Planning Officer: Charlotte Easton
Planning Application Ref: **AW/280/18/T**
Location: **10 Faresmead, Aldwick PO21 3DQ**
Description of works: **Reduce 3No. Hornbeams by 3m**
Reasons Given: None given

To Reduce 2x Hornbeam Trees

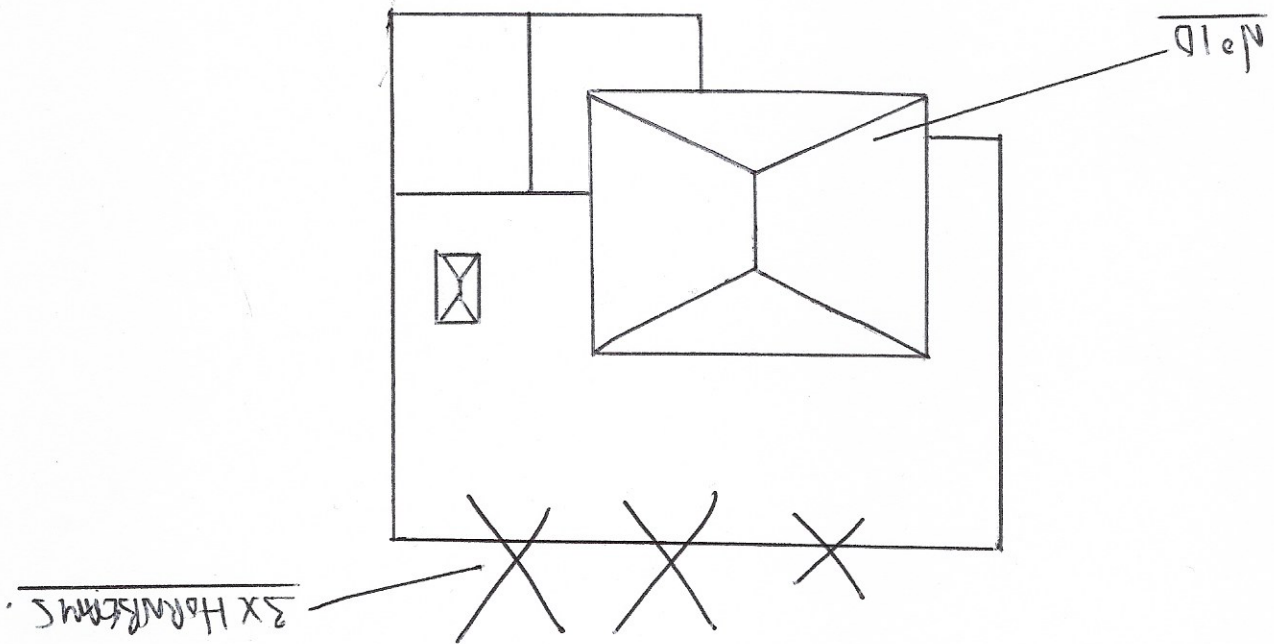
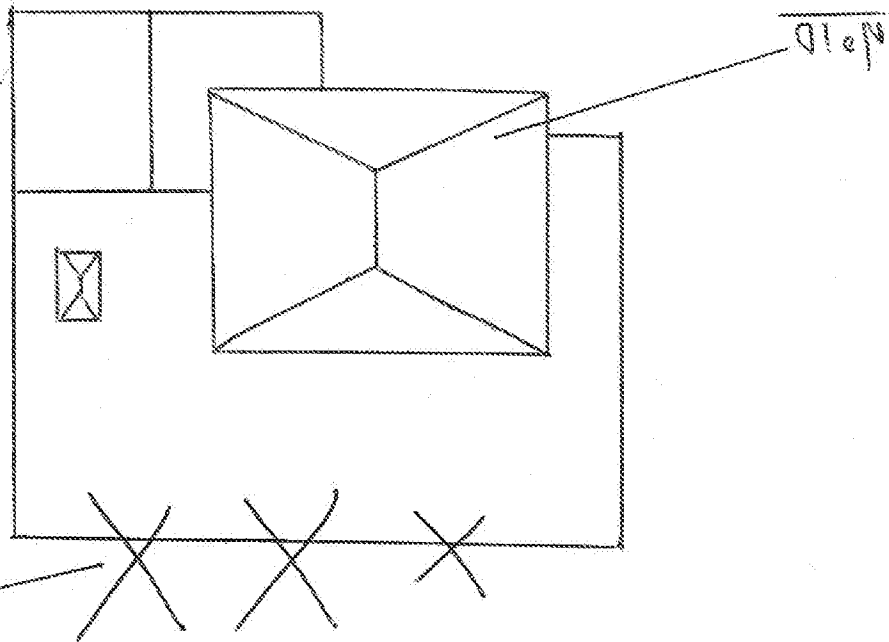
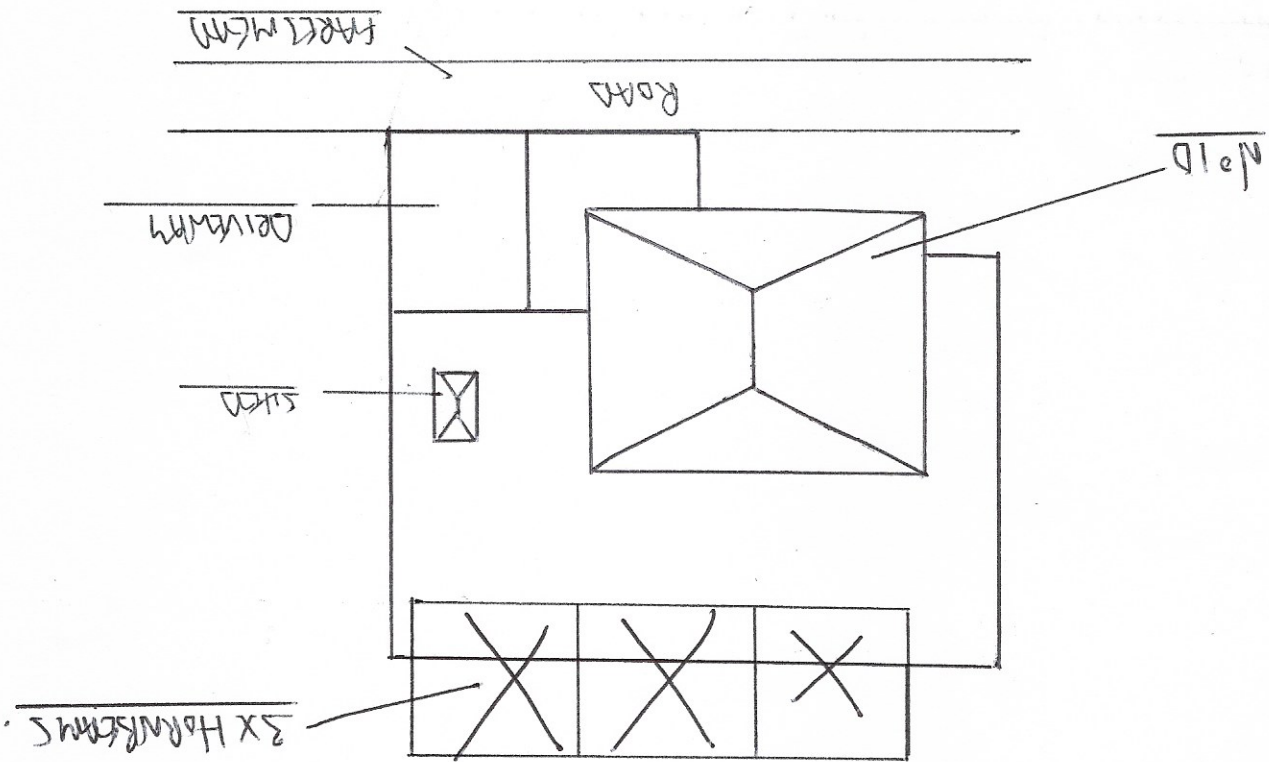
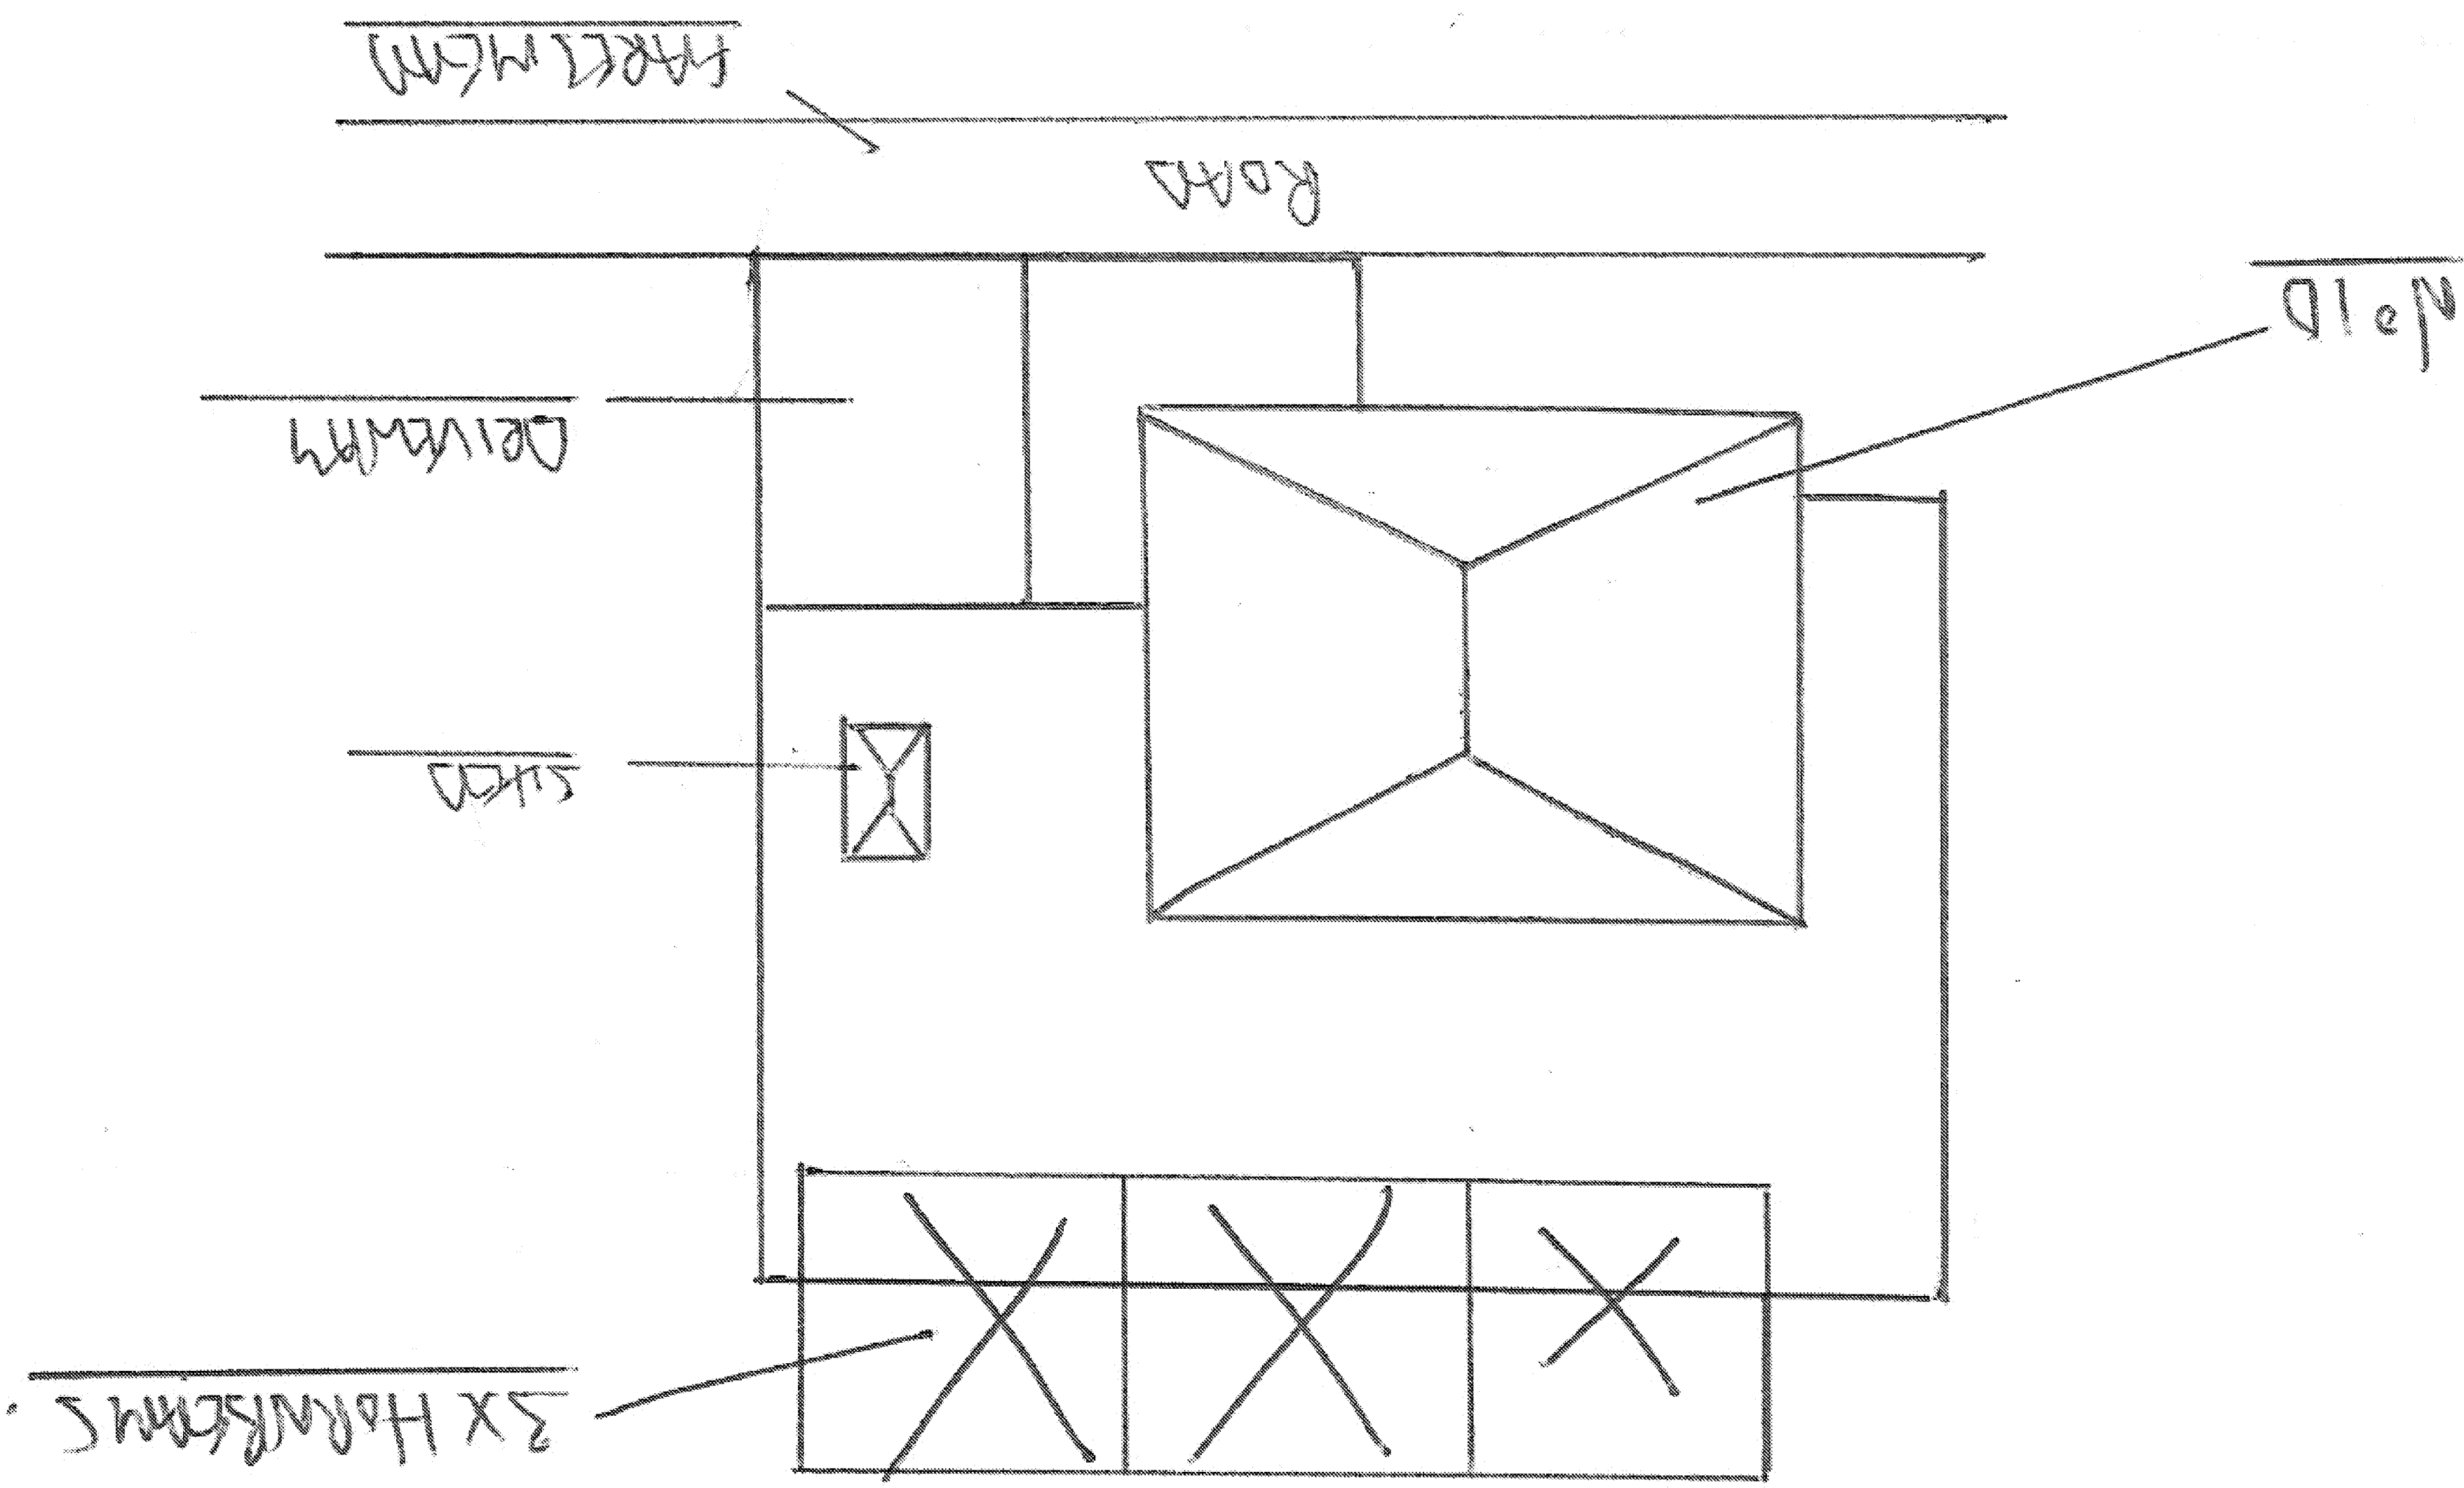
- Outwardly and from a distance these trees appear to be in a fine physiological state and form part of an established boundary tree group.
- The central tree is dominant and despite having multiple stems, presents an attractive crown profile. The two companion trees on either side are slightly suppressed but nevertheless are constituent parts of the group and important for its cohesion.
- They grow at the rear of the property and can be seen from surrounding properties and public highway (road and footway). They are a good distance from dwellings and do not present any obvious problems.
- The applicant proposes a 3metre reduction, which must be assumed to apply to both top height and lateral spread. If the full extent of meterage is applied on all aspects this would exceed the recommendations in British Standard 3998:2010 – Tree Work.

- The work proposed is severe and if enacted to the maximum extent of 3m on all aspects would result in damaging loss of crown volume. It has not been justified on arboricultural grounds.
- The trees are an established feature in the local landscape and appear to be in adequately sound and healthy condition. The tree surgery proposed in the application would result in excessive reduction of the tree's landscape impact and undue detriment to the visual amenities of the locality.

- I recommend **REFUSAL** for this application.
